WEST SUSSEX COUNTY COUNCIL CONSULTATION

TO:	Arun District Council FAO: Andrew Wood
FROM:	WSCC - Highways Authority
DATE:	13 February 2020
LOCATION:	Eastlands Littlehampton Road Worthing BN12 6PB
SUBJECT:	FG/8/20/PL Erection of 1 No. equestrian dwelling & retention of 1 No. gazebo & 2 No. carports. This application is a Departure from the Development Plan & may affect a Public Right of Way.
DATE OF SITE VISIT:	n/a
RECOMMENDATION:	Modification
S106 CONTRIBUTION TOTAL:	n/a

Title:
Proposed Site Plan

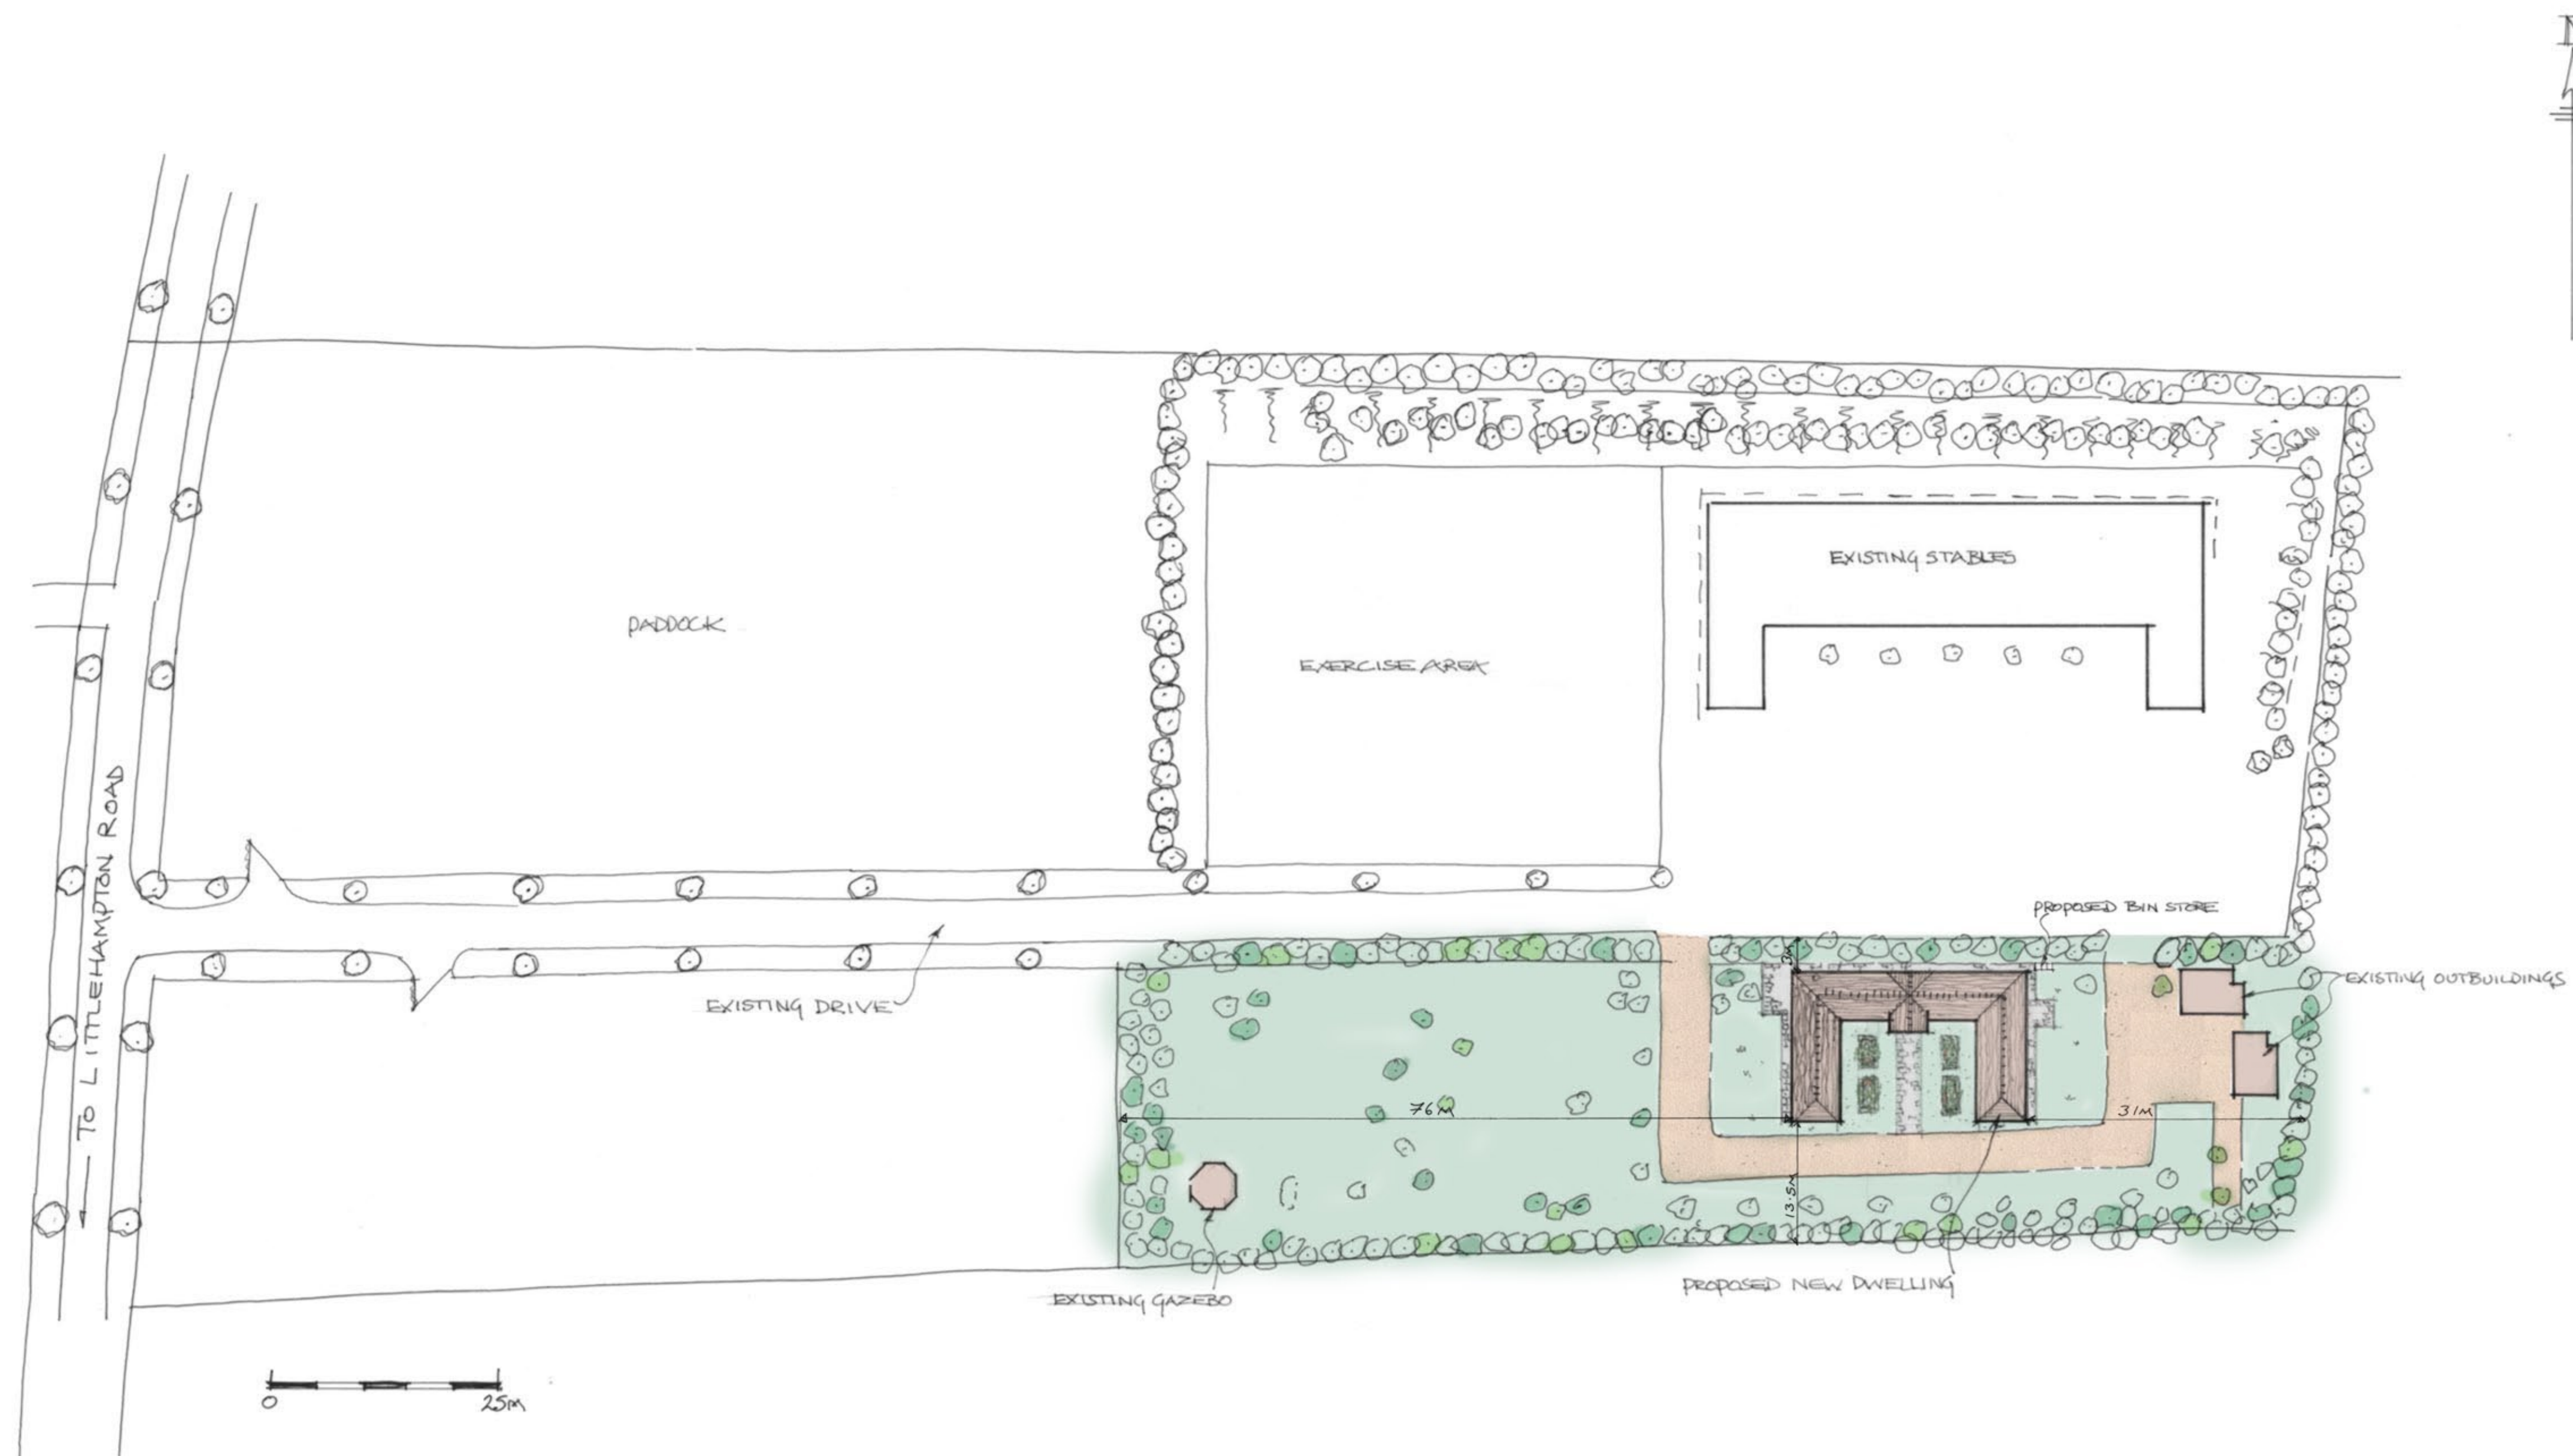
The applicant proposes a four car parking provision for the new dwelling. However, this has not been demonstrated on the plans.

The applicant has proposed a nil cycle parking provision, as per the WSCC and Arun policy we wish to see cycle storage implemented in the form of lockable covered storage.
